Subject: Double Spur Ranch Minor Subdivision – (MS-23-005)

The Park Planning Division of the Parks and Community Services Department has reviewed the Double Spur Ranch Minor Subdivision development application and has the following **preliminary** comments on behalf of El Paso County Parks. This application and the following comments and recommendations will be presented to the Park Advisory Board for endorsement on June 14, 2023:

Double Spur Ranch Minor Subdivision Review

DOUBLE SPUR RANCH MINOR SUBDIVISION FINAL PLAT

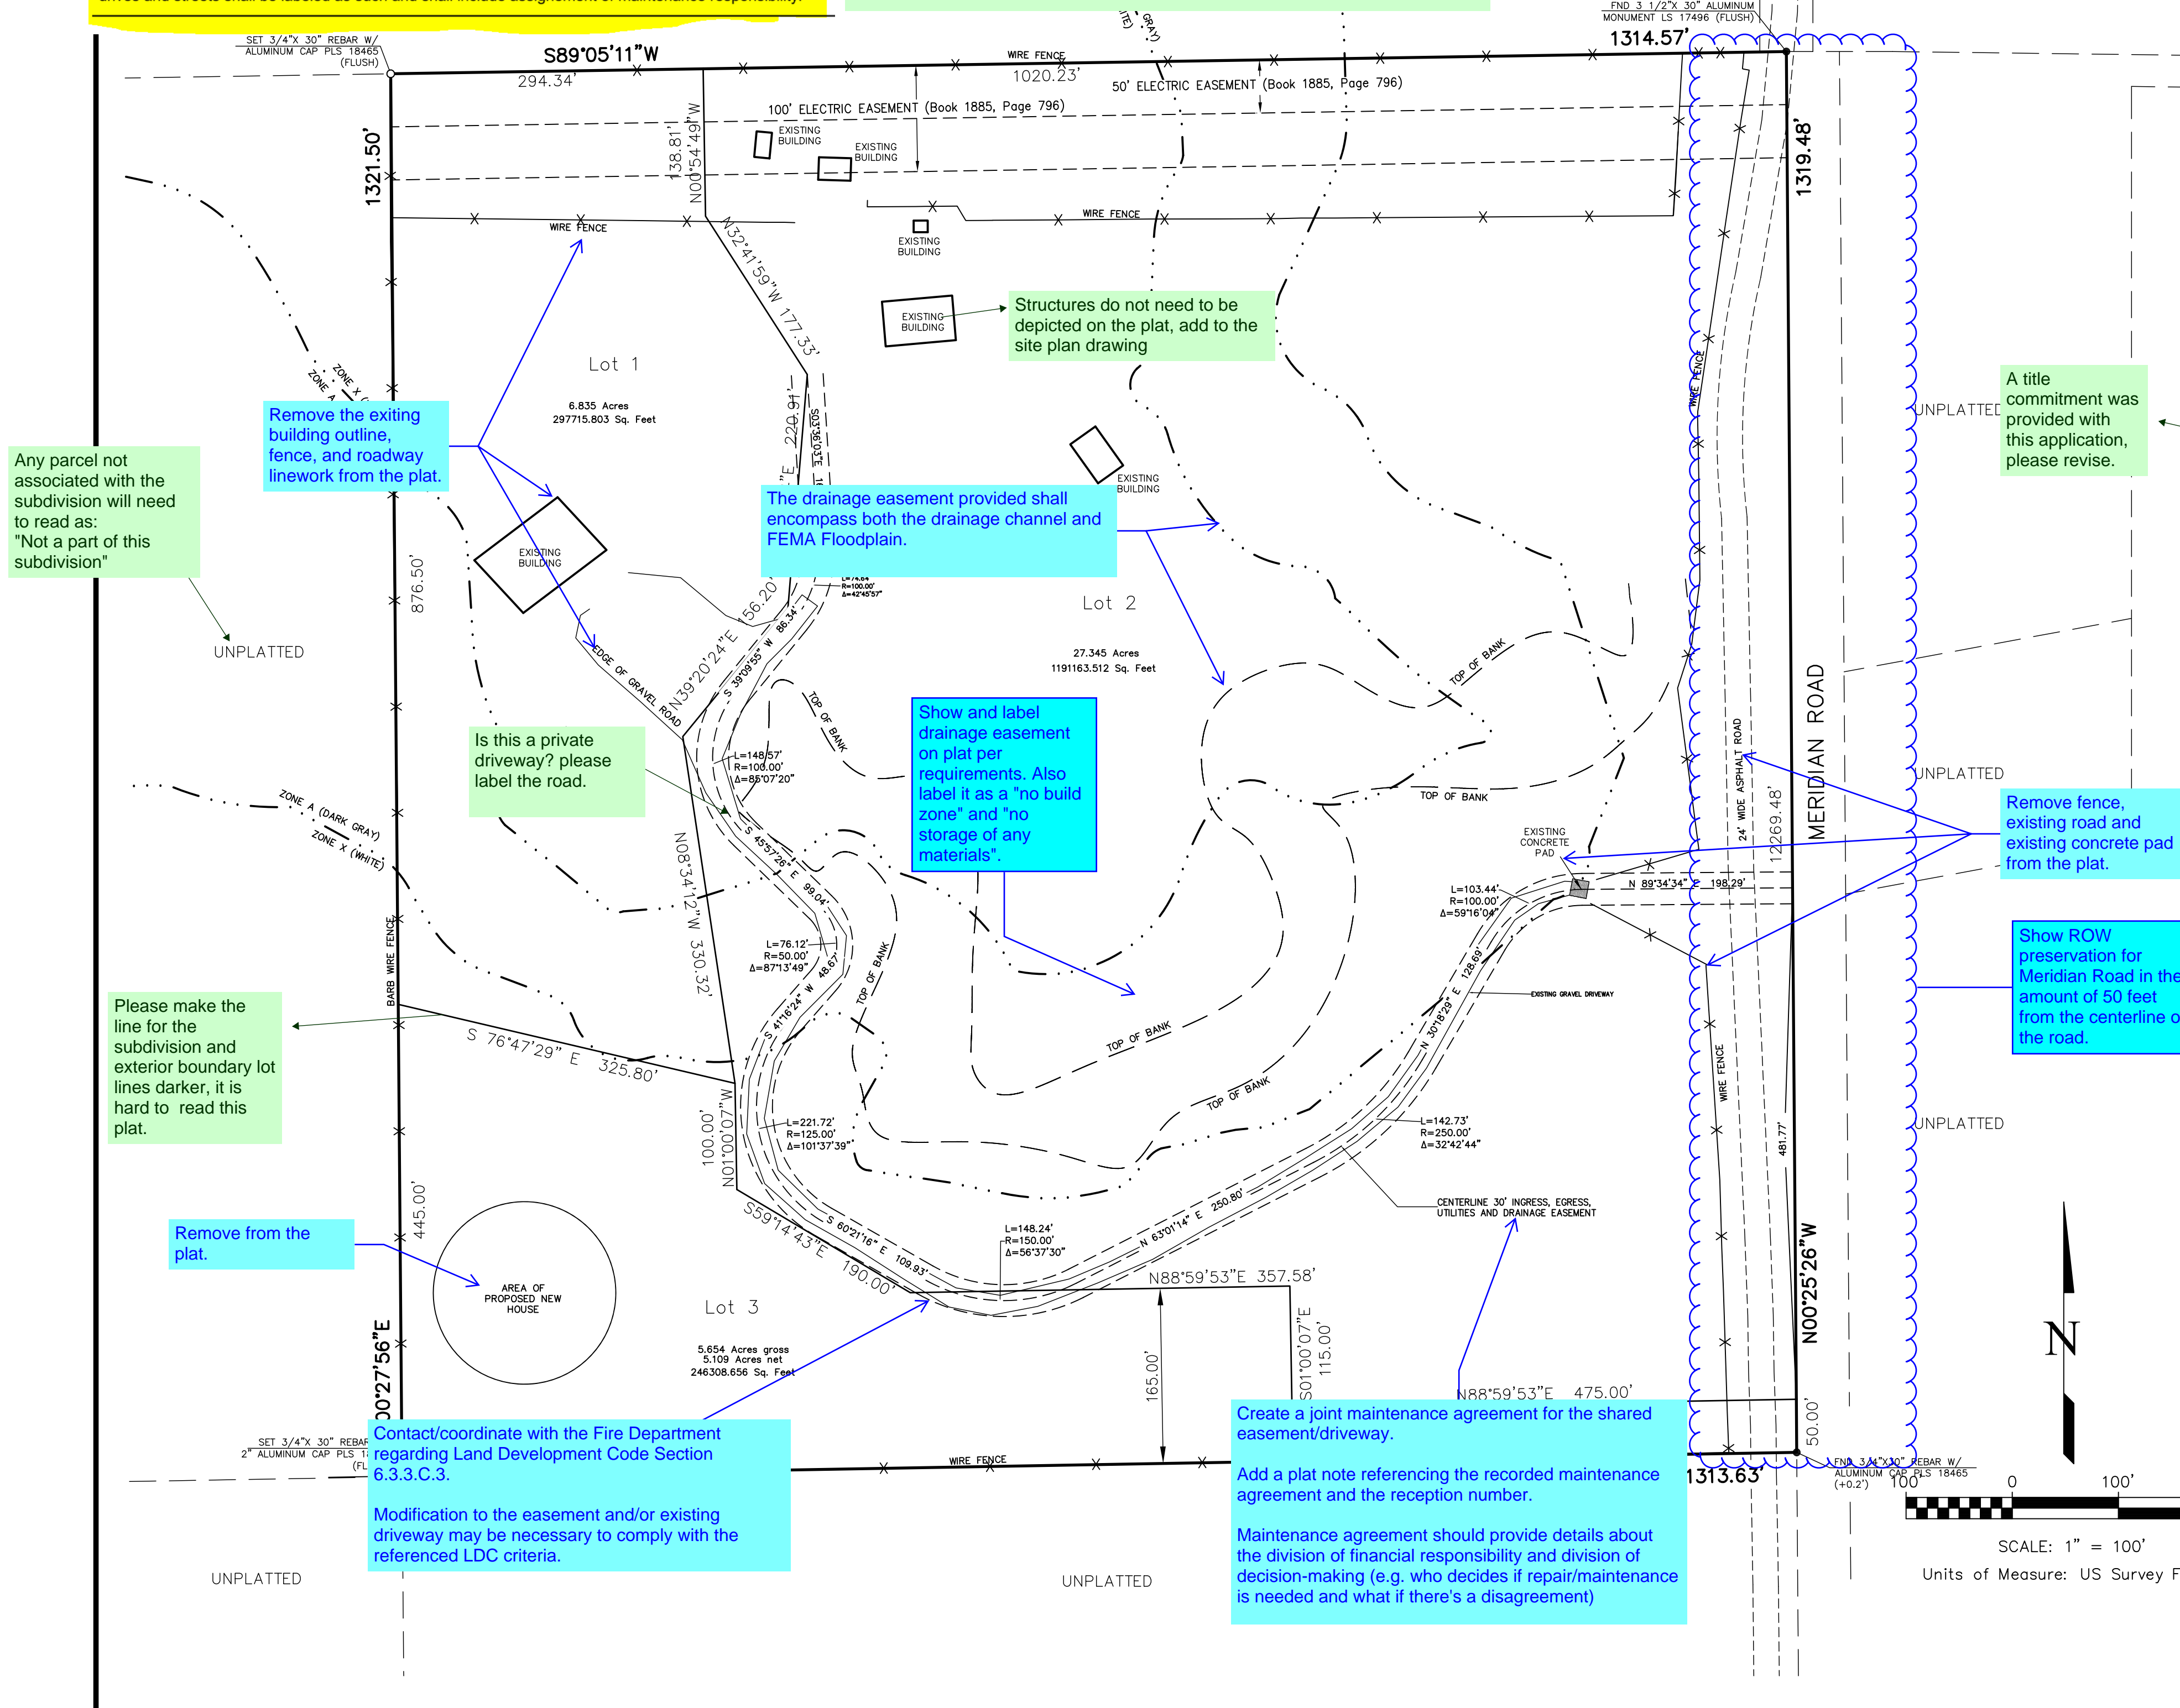
The 2022 El Paso County Parks Master Plan shows impacts to the proposed Latigo Secondary Regional Trail, which traverses the northern boundary of the property, and will provide regional trail access from the proposed Latigo Trails Open Space to nearby existing Pineries Open Space. This particular stretch of the Latigo Regional Trail is considered an alternative proposed route until such time that additional trail easements can be secured along either the primary or alternative routes, and the final trail alignment determined. The requested 25-foot trail easement may be collocated within the existing 50' electrical easement along the northern property boundary.

The Park Advisory Board recommends that the Planning Commission and the Board of County Commissioners include the following conditions when considering and/or approving the Double Spur Ranch Minor Subdivision: (1) designate and provide to El Paso County a 25-foot trail easement along the northern boundary of Double Spur Ranch Minor Subdivision that allows for the construction, maintenance, and public access of the Latigo Secondary Regional Trail, and dedicate the aforementioned easement to El Paso County prior to the recording of the Minor Subdivision; (2) fees in lieu of land dedication for regional park purposes in the total amount of \$1,380 will be required at the time of the recording of the Minor Subdivision.
